Re: J0424-2449
Lot 16 Duncans Creek

Pages or sheets covered by this seal: I68935257 thru I68935259

October 17, 2024

Job J0424-2449	Truss A02	Truss Type COMMON	Qty 6	Ply 1	Lot 16 Duncans Creek Job Reference (optional)	165230015
-------------------	--------------	----------------------	----------	----------	--------------------------------------------------	-----------

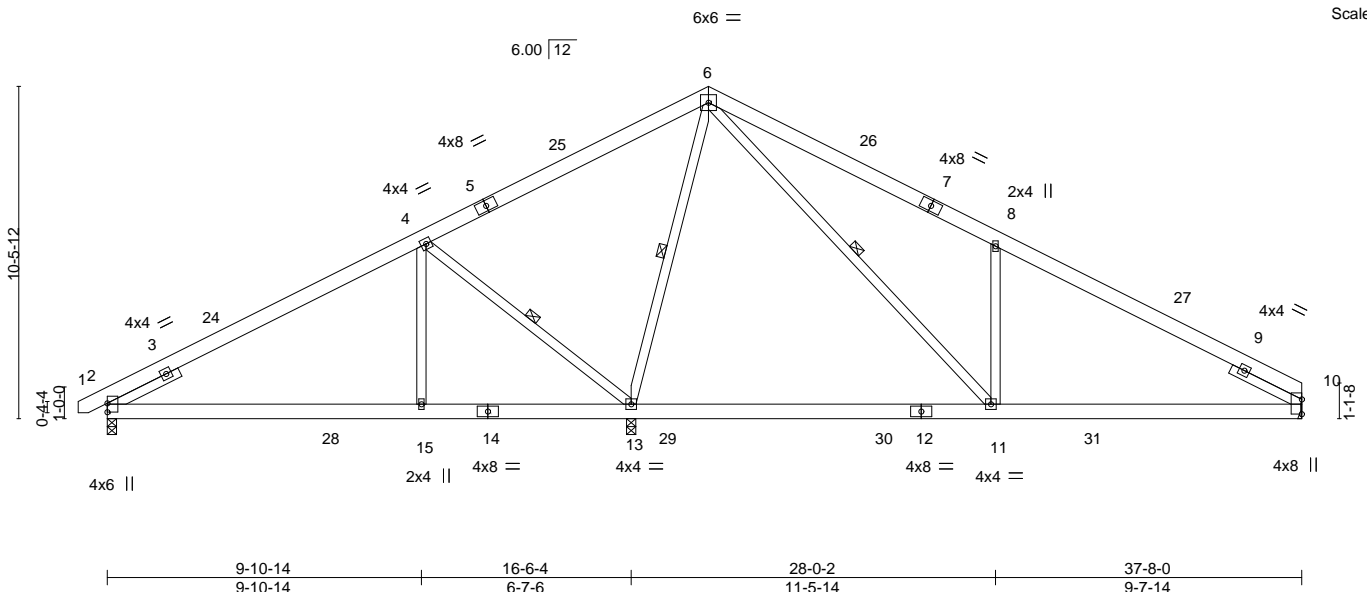
REPAIR: 12" LONG CRACK ON BOTTOM CHORD BELOW PLATE AT JOINT 10.

ATTACH 1/2" PLYWOOD OR OSB GUSSET (15/32" RATED SHEATHING 32/16 EXP 1) TO EACH FACE OF TRUSS WITH (0.131" X 2.5" MIN.) NAILS PER THE FOLLOWING NAIL SCHEDULE: 2 X 3'S - 2 ROWS, 2 X 4'S - 3 ROWS, 2 X 6'S AND LARGER - 4 ROWS: SPACED @ 4" O.C. NAILS TO BE DRIVEN FROM BOTH FACES. STAGGER SPACING FROM FRONT TO BACK FACE FOR A NET 2" O.C. SPACING IN EACH COVERED TRUSS MEMBER. USE 2" MEMBER END DISTANCE.

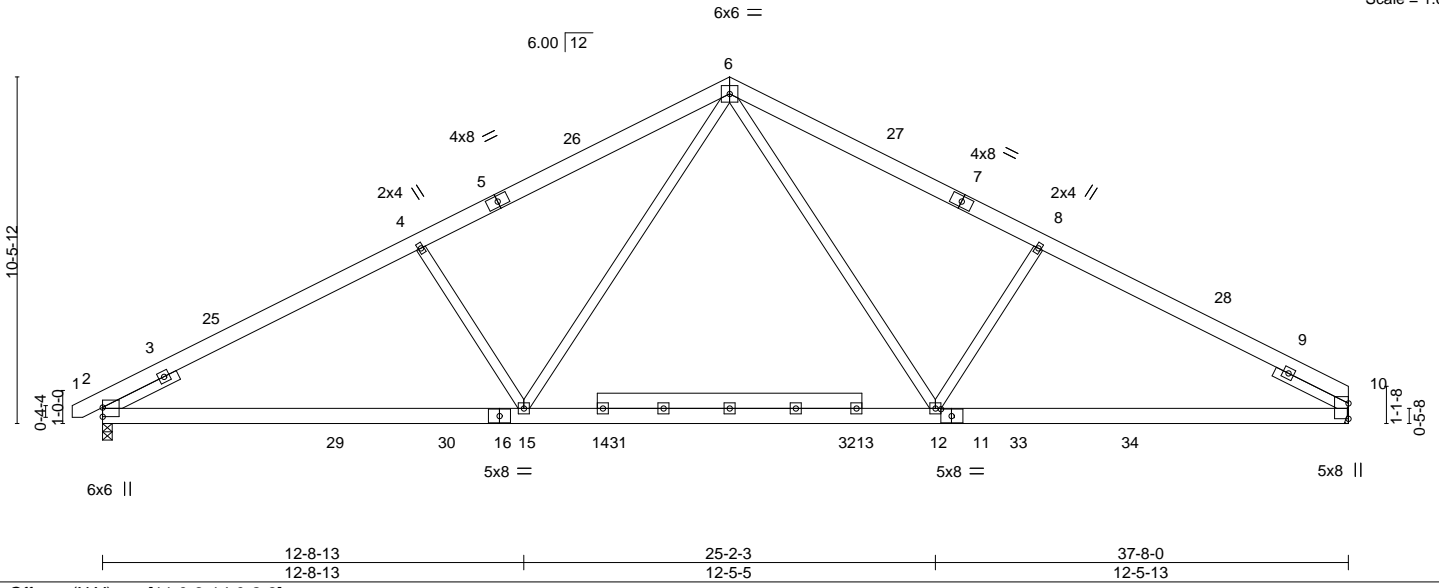
SAME REPAIR AS A02. (168935257)
